Application Reference: BR/82/26/PL

Site Address: 63 Annandale Avenue, Bognor Regis, PO21 2DN

Proposal: Demolition of existing dwelling and erection of a three-storey building comprising nine self-contained flats.

| DRAWING<br>Proposed<br>Block Plan         |                  |

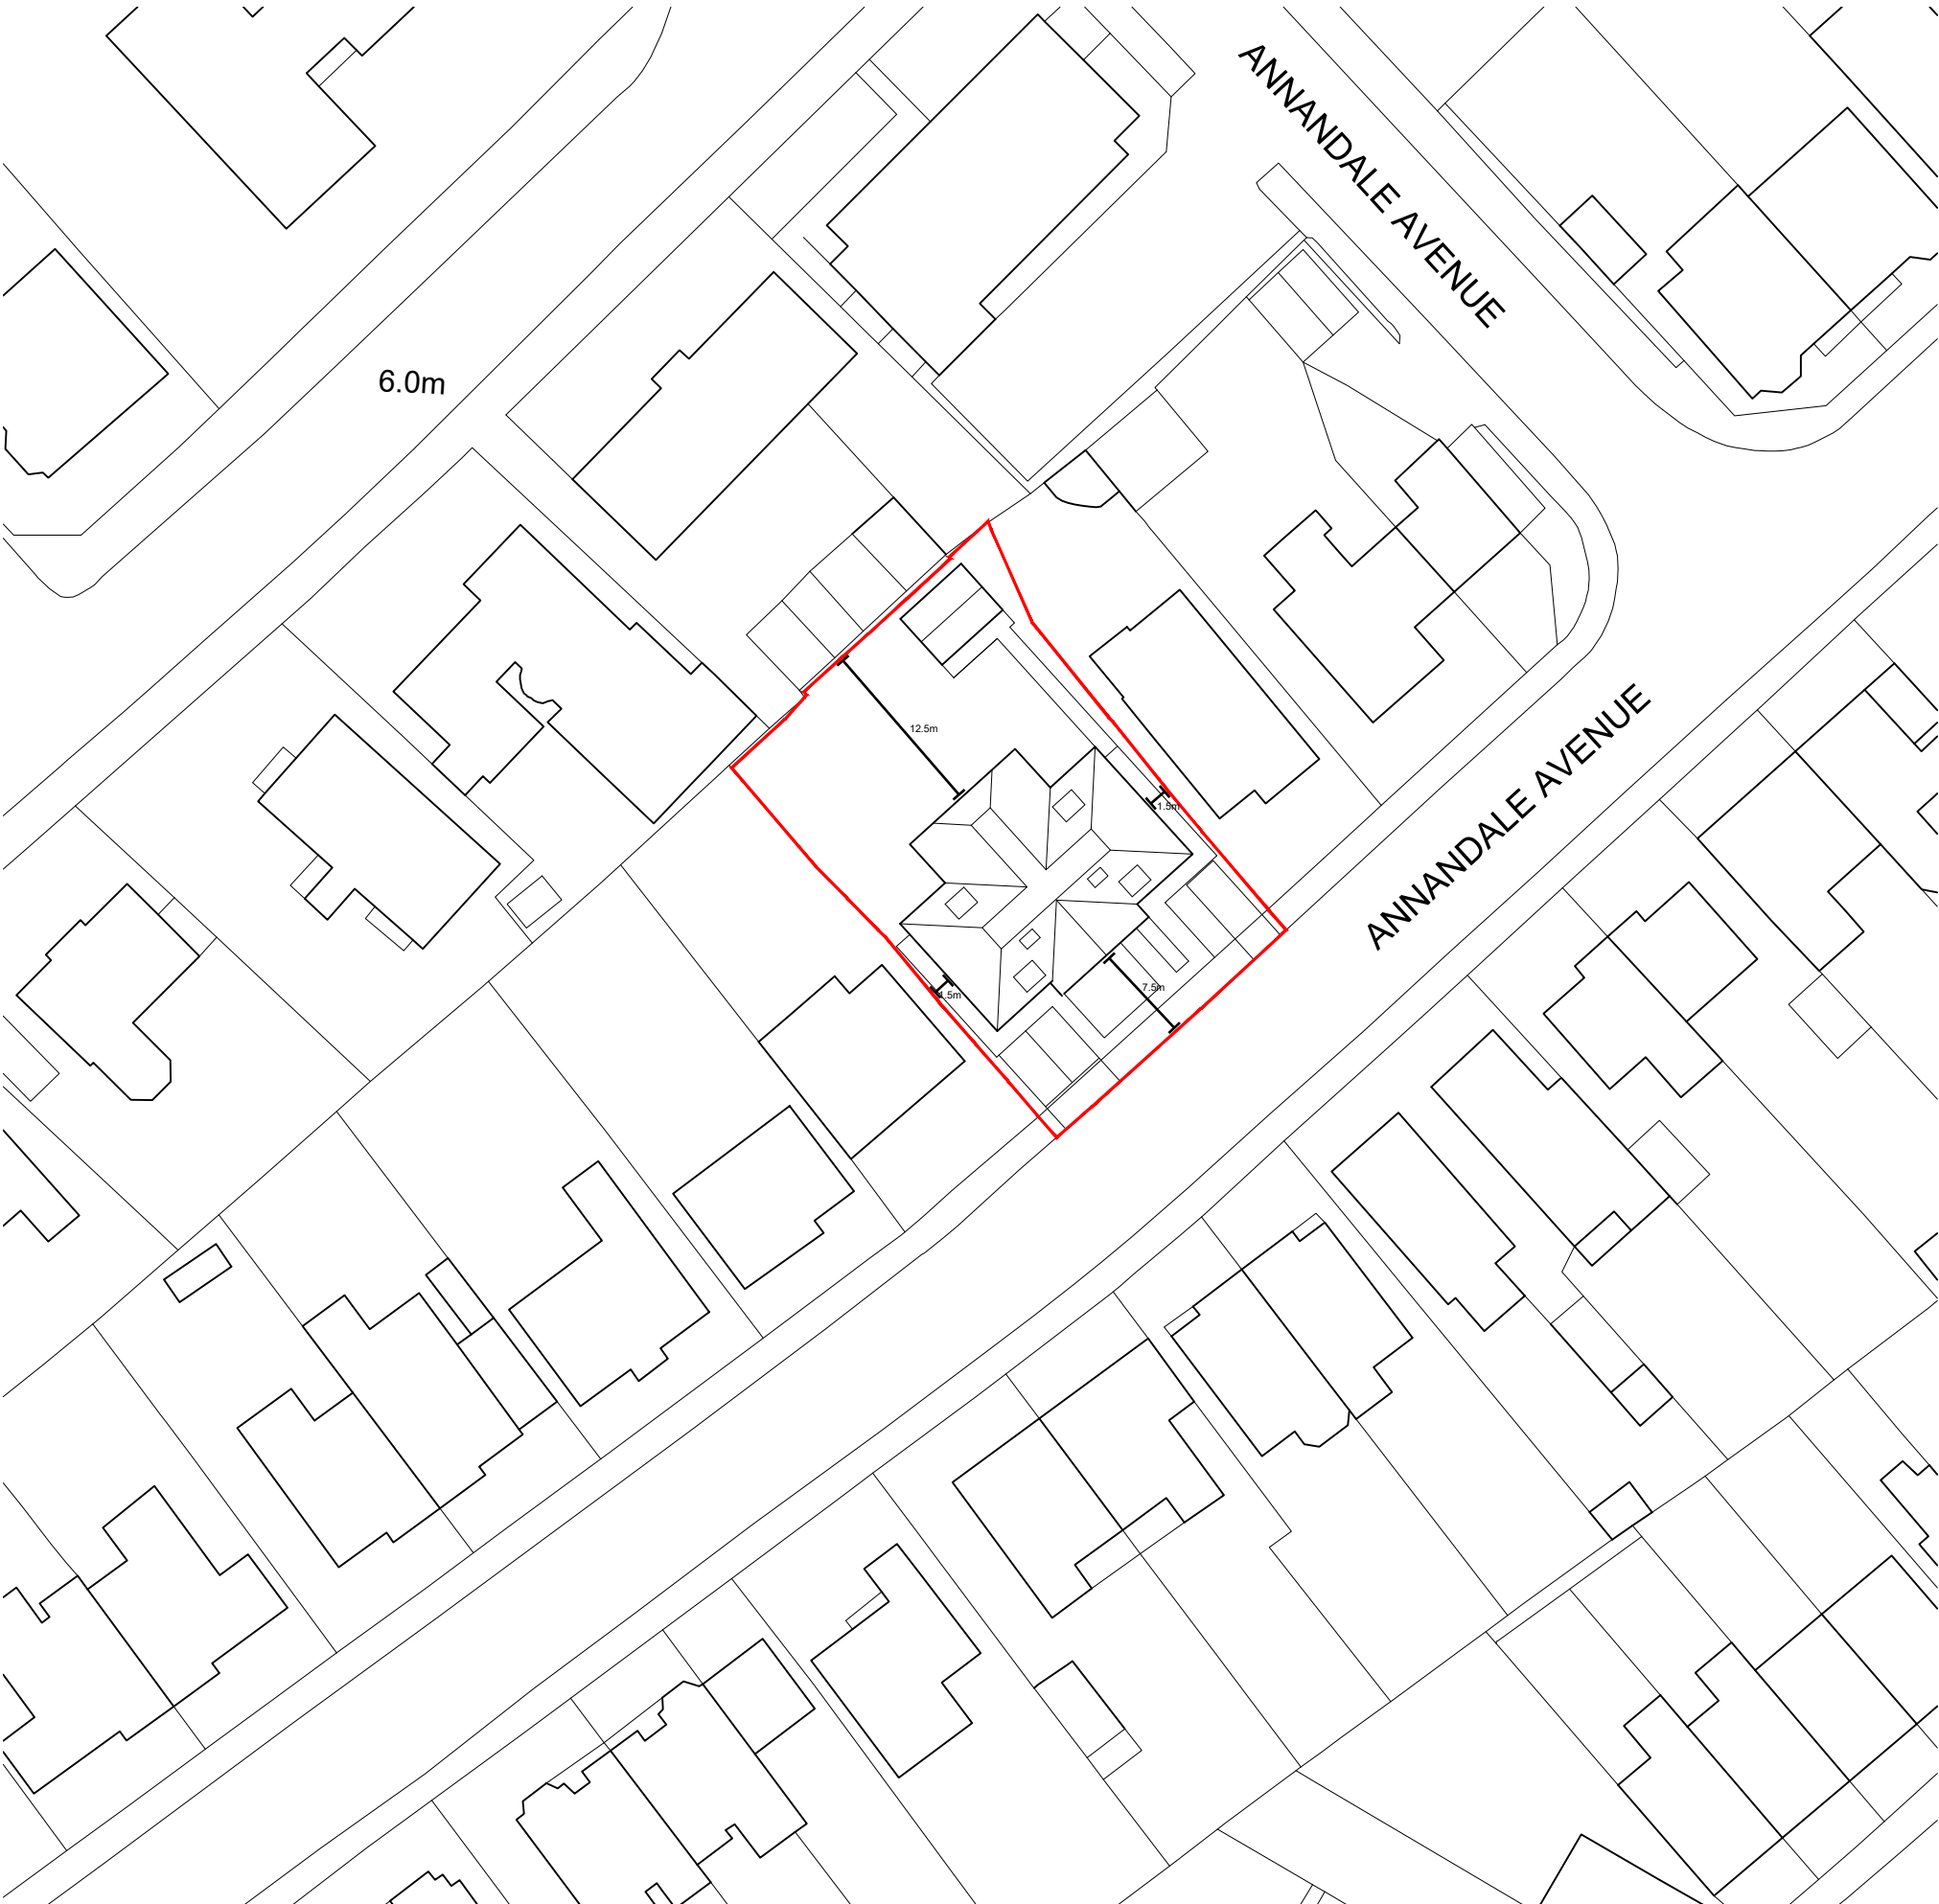
The plans indicate that only three on-site parking spaces are provided to serve nine self-contained flats. Whilst the applicant may rely upon assumptions regarding reduced private car ownership, the development is also likely to generate vehicle movements associated with visitors, carers or support staff, healthcare professionals, maintenance contractors, deliveries and servicing. This additional demand is likely to increase pressure on the already heavily used on-street parking within Annandale Avenue, to the detriment of highway safety and the convenience of existing residents. This is of particular concern to us, as we own a 5-bedroom detached dwelling with no off-street parking.

Furthermore, the application provides insufficient evidence that refuse and recycling facilities have been designed to adequately serve a development of this scale. The Council should be satisfied that sufficient refuse capacity is available, that collection arrangements can operate safely and efficiently, and that bin storage will not result in visual clutter, obstruction of the site entrance or harm to the amenities of neighbouring occupiers.

DRAWING
Proposed Floor Plans

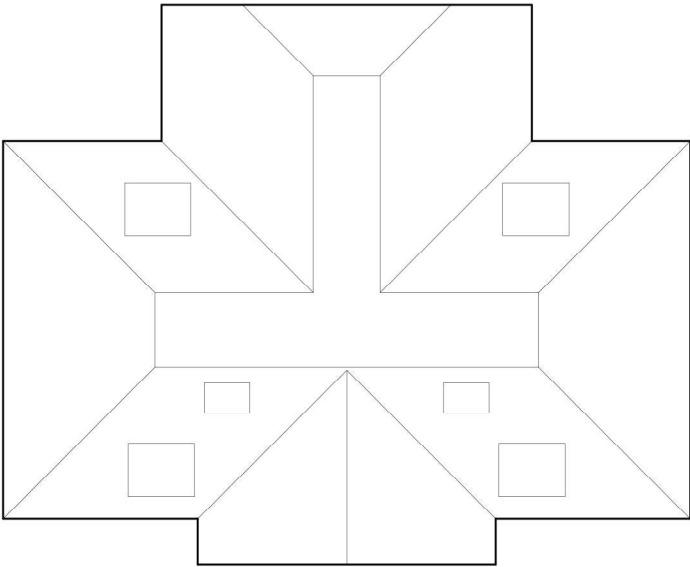
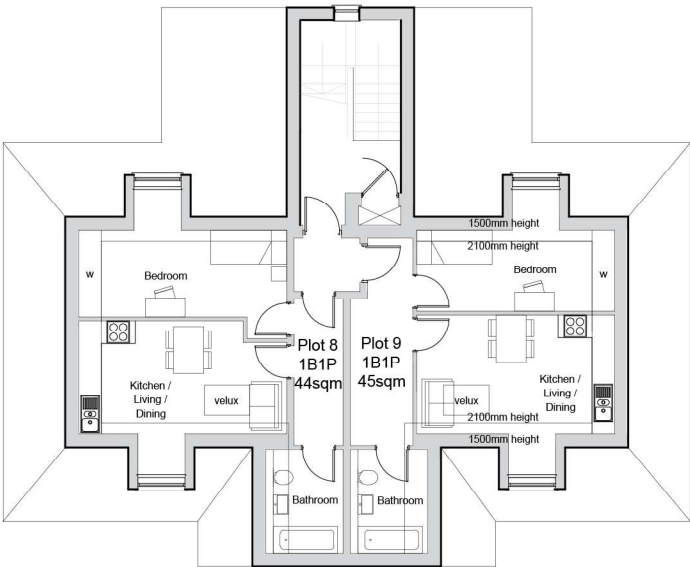
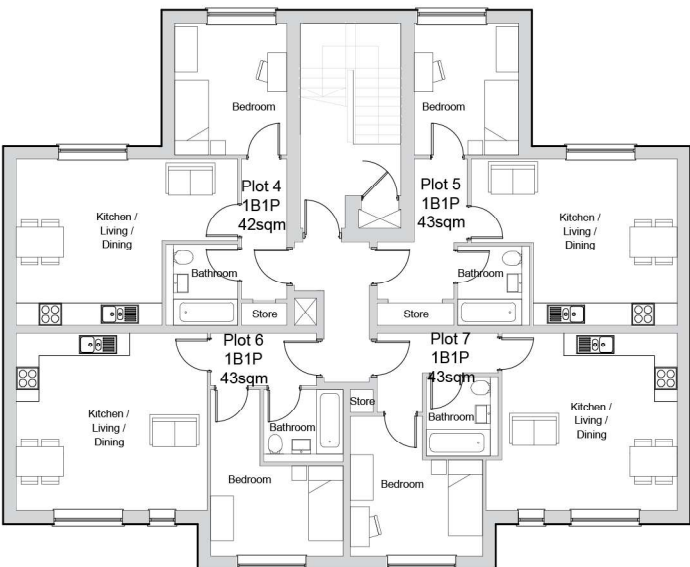
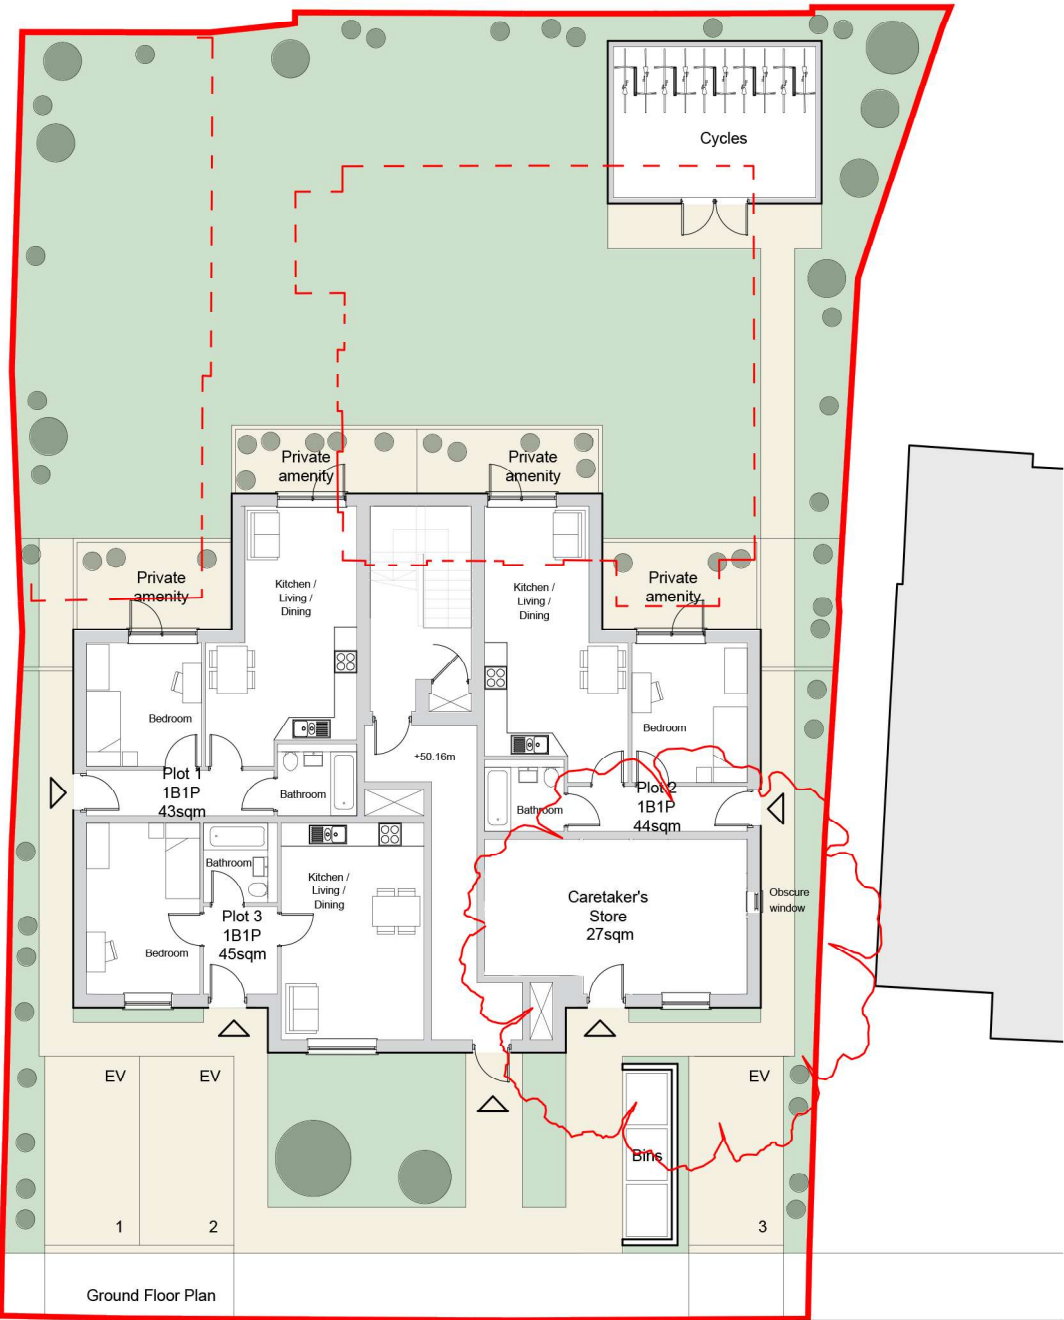
The proposed three-storey building containing nine self-contained flats represents an over-intensive form of development that is wholly out of keeping with the established character of Annandale Avenue.

This part of the avenue is characterised by detached and semi-detached residential properties set within spacious plots with generous separation distances and mature landscaping. The proposed building, by reason of its scale, height, bulk, massing and footprint, would introduce an incongruous and dominant form of development that bears little relationship to the prevailing pattern of development.

Given the constrained nature of the site, a building of this scale would create an overbearing and oppressive presence, resulting in a significant loss of outlook and an increased sense of enclosure. The height and proximity of the development would also reduce daylight and sunlight reaching neighbouring properties.

Furthermore, the introduction of multiple windows across three storeys would result in direct overlooking into neighbouring habitable rooms and private gardens, leading to a substantial loss of privacy.

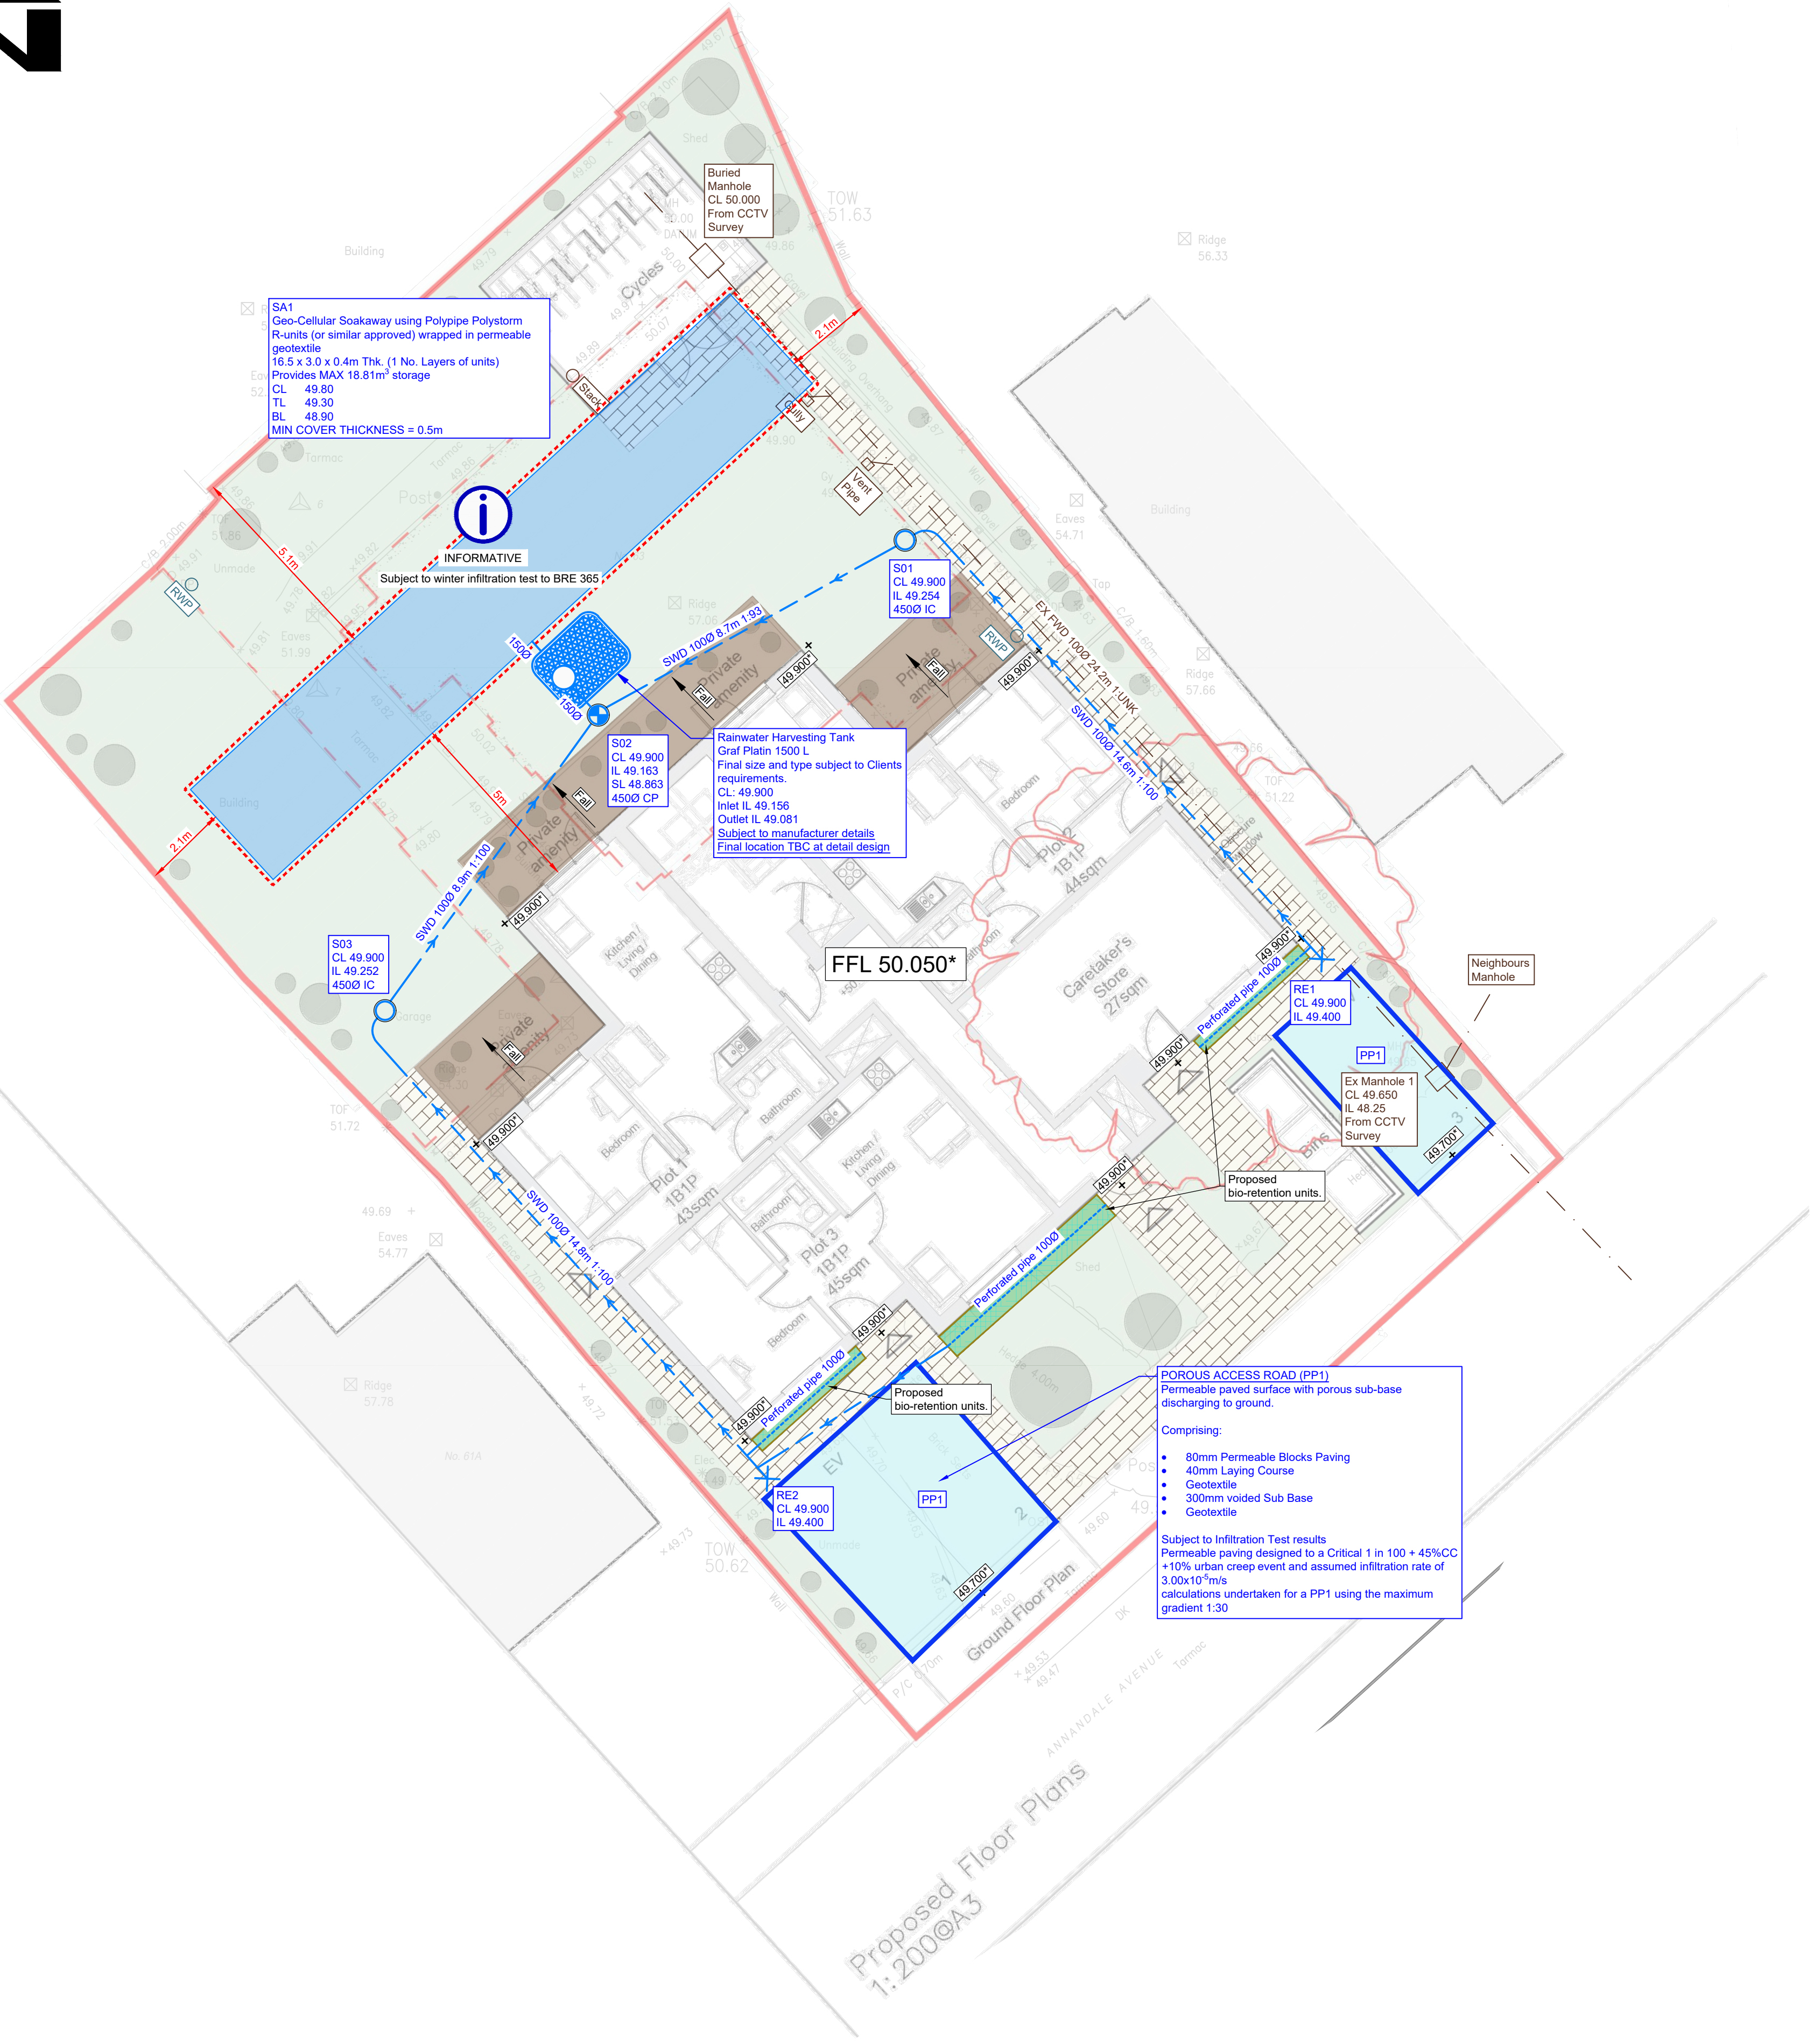
The submitted application does not clearly explain how the existing shared drainage arrangements serving neighbouring property 63A will be protected or accommodated during and after construction.

The current foul drainage infrastructure passes through the application site, yet the submitted information provides little detail regarding how this infrastructure will be protected, diverted where necessary, maintained during construction or accommodated within the completed development.

Given the substantial increase in residential intensity proposed, greater confidence is required that existing neighbouring drainage infrastructure will not be compromised.

The Local Planning Authority should therefore require comprehensive evidence that adequate drainage capacity exists and that neighbouring properties will not be adversely affected.
